East Anglia ONE North and East Anglia TWO Offshore Windfarms

Applicants' Comments on Suffolk Preservation Society's Deadline 5 Submission

Document Reference: ExA.AS-20.D6.V1

Date: 24th February 2021

Figure: 8g
CHVP3: PROW between Moor Farm and Little Moor Farm

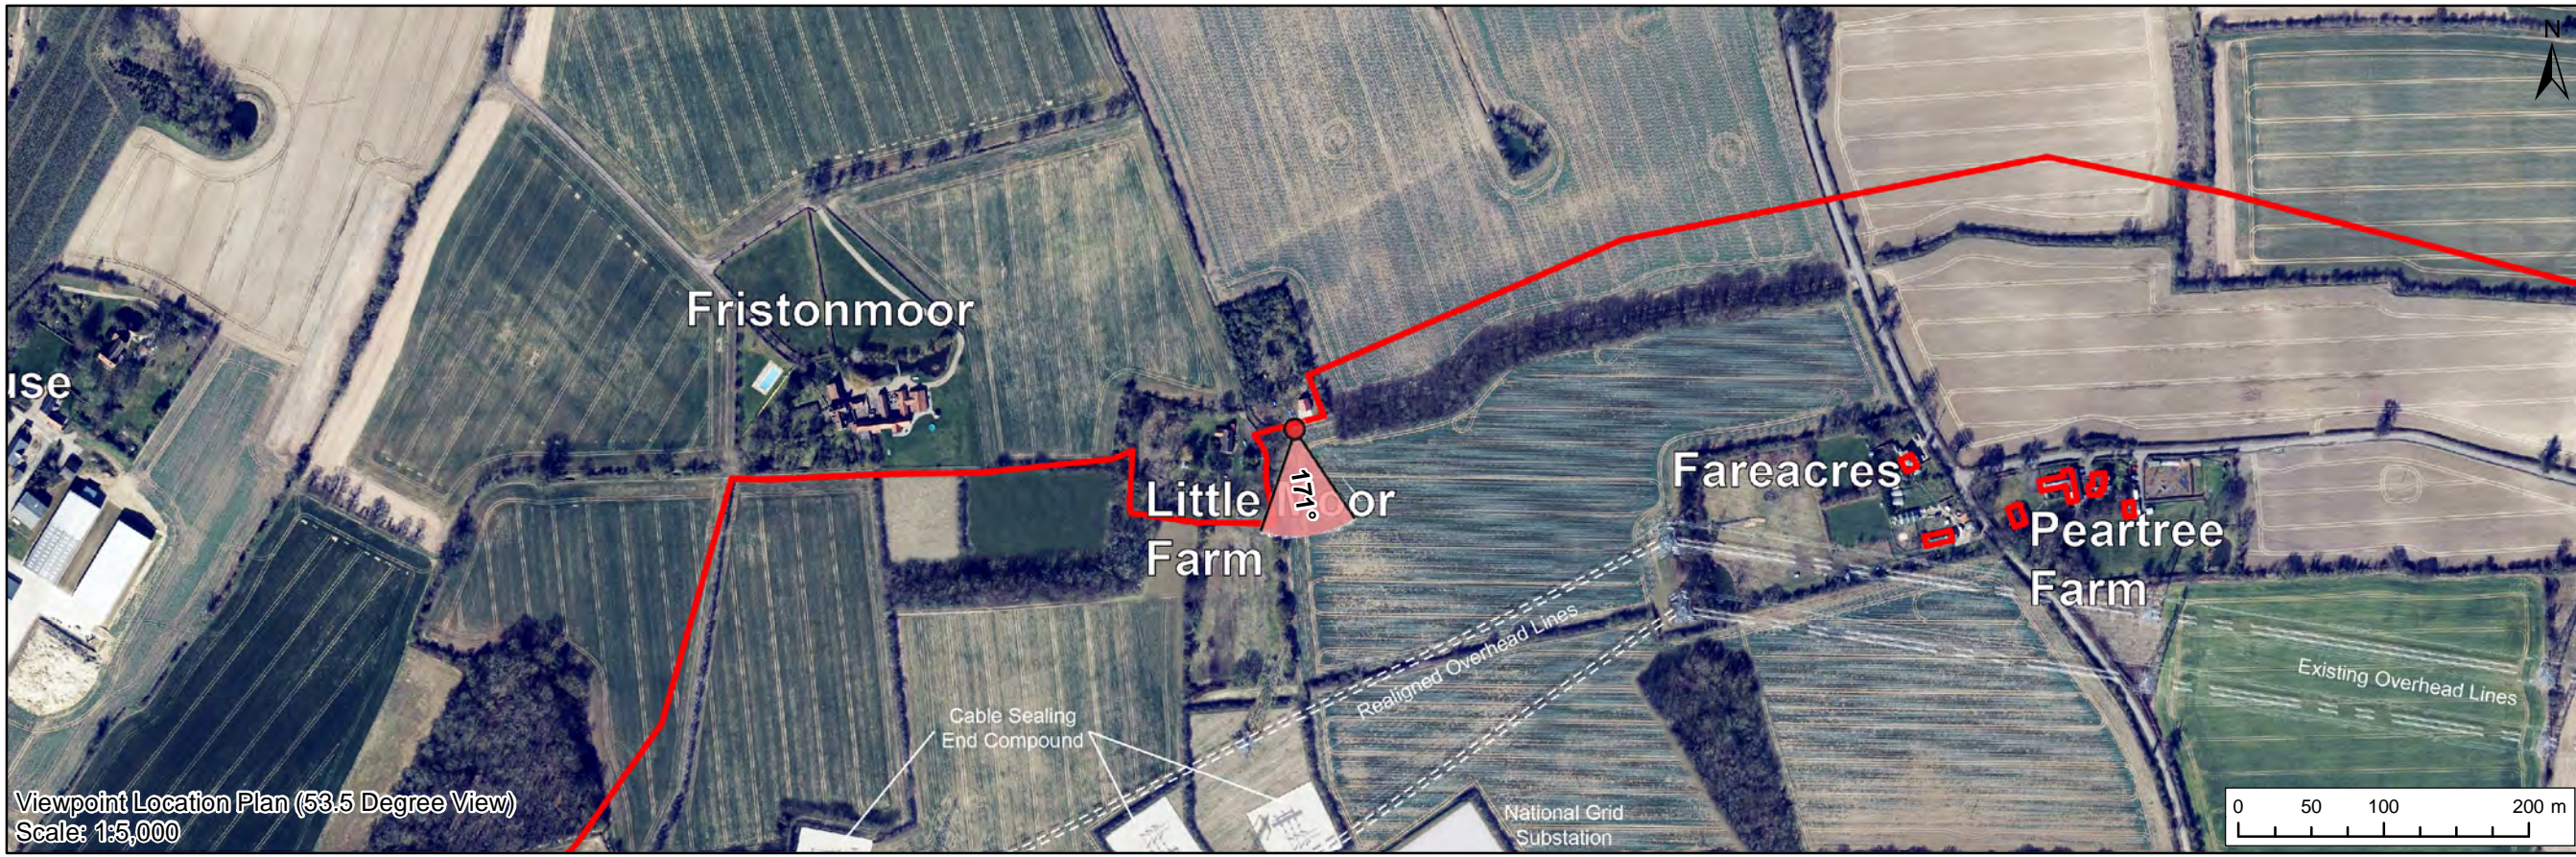
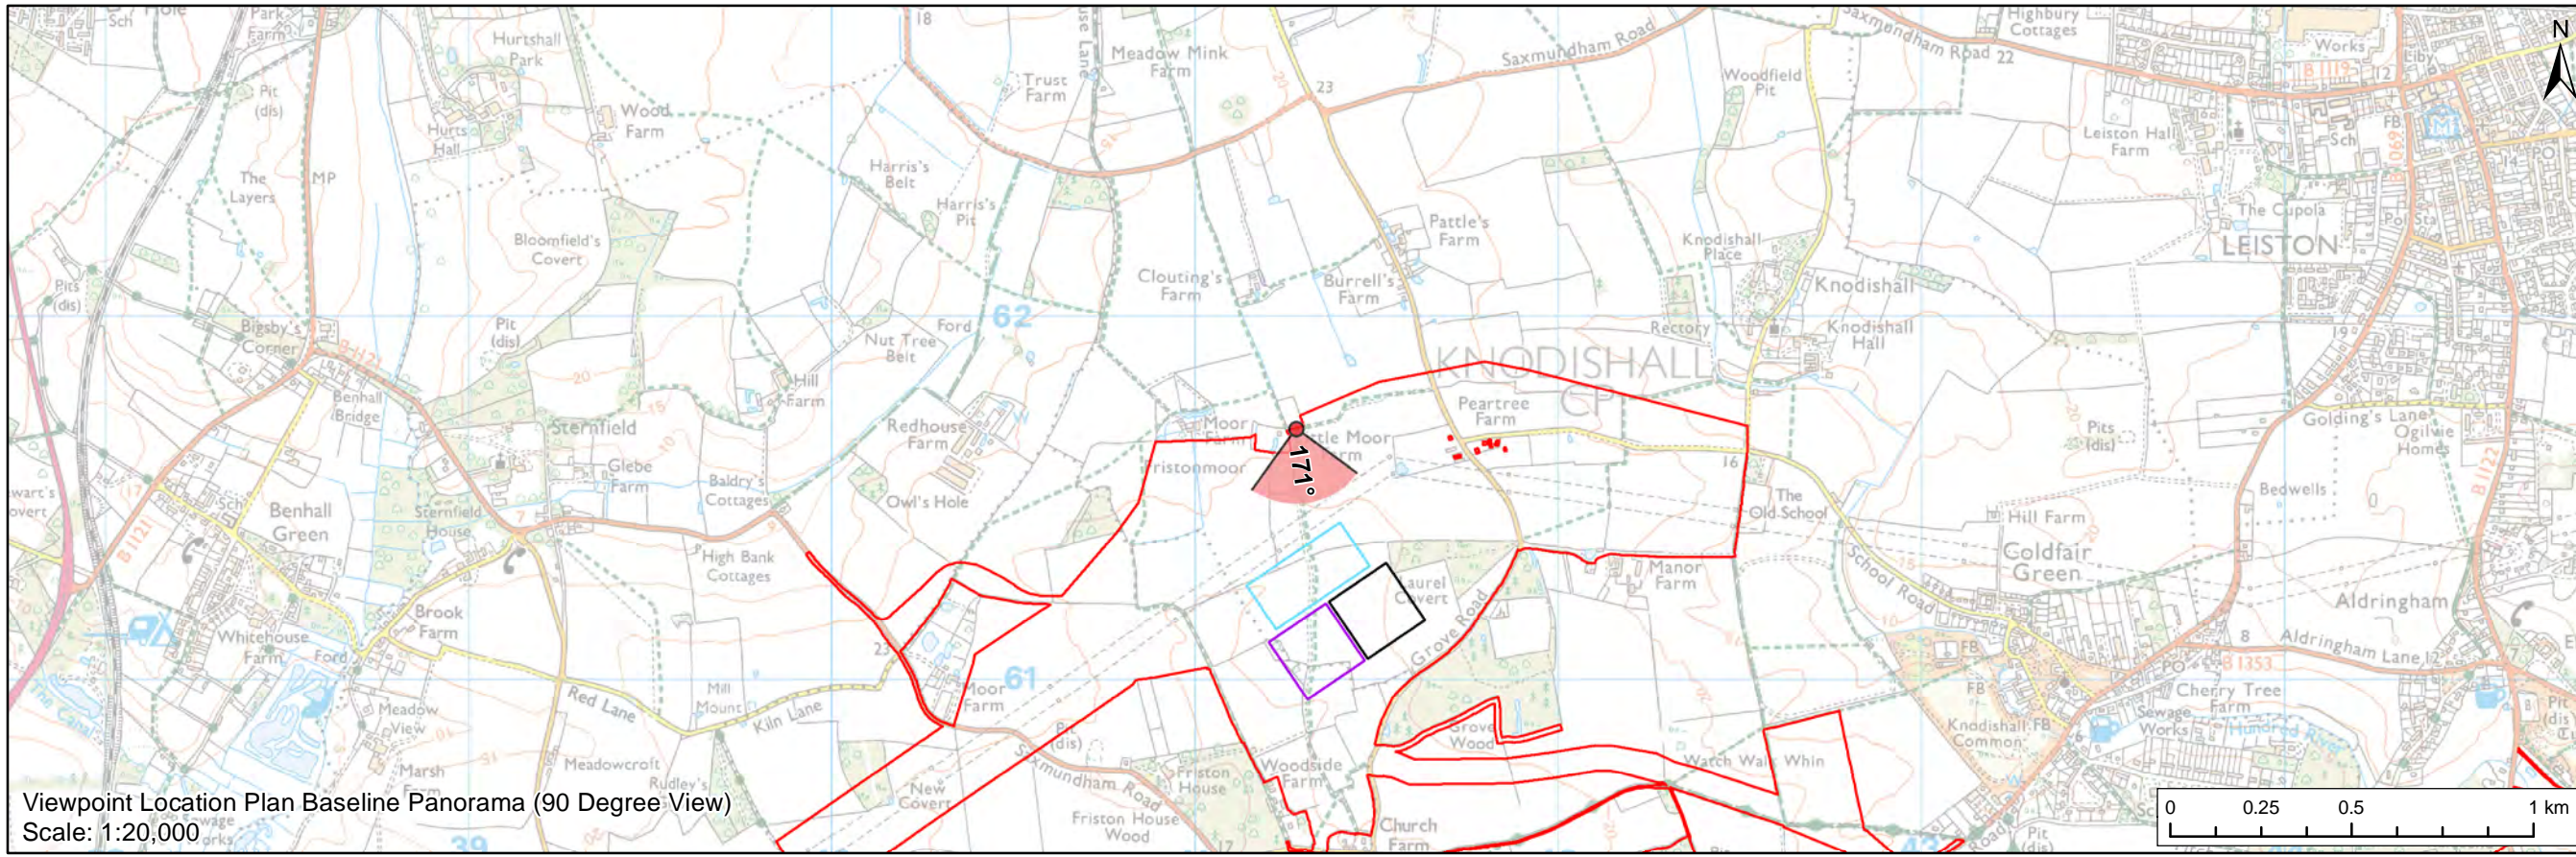
ID	Written Representation	Applicants' Comments
		would mitigate the predicted harm to the significance of the Listed farmhouses.
16	<p>CHVP4 PRoW E of Little Moor Farm - The visualisation effectively demonstrates that the relationship between Moor Farm and Little Moor Farm and the wider landscape and in particular St Mary's Church, will be lost. The landscaping proposed merely exacerbates the loss of this visual, historical and cultural link. Despite the reduction in height of some of the structures the gantries of the National Grid and Western substation remain highly prominent in the landscape.</p>	<p>The comments here by SPS are essentially the same as those addressed in the previous response on CHVP3.</p> <p>The Applicants consider that the proposed planting offers substantive mitigation of the adverse change in the character of the setting of Little Moor Farm. The loss of the views towards the church, which had already been identified in the original heritage assessment (ES Appendix 24.7 (APP-519/520) would impact on the significance of the church and this is recognised in both the original and revised assessments of the church. However, the loss of this view does not materially affect the significance of Little Moor Farm and therefore the provision of screening vegetation at this location is judged to be an effective mitigation measure in this case.</p>
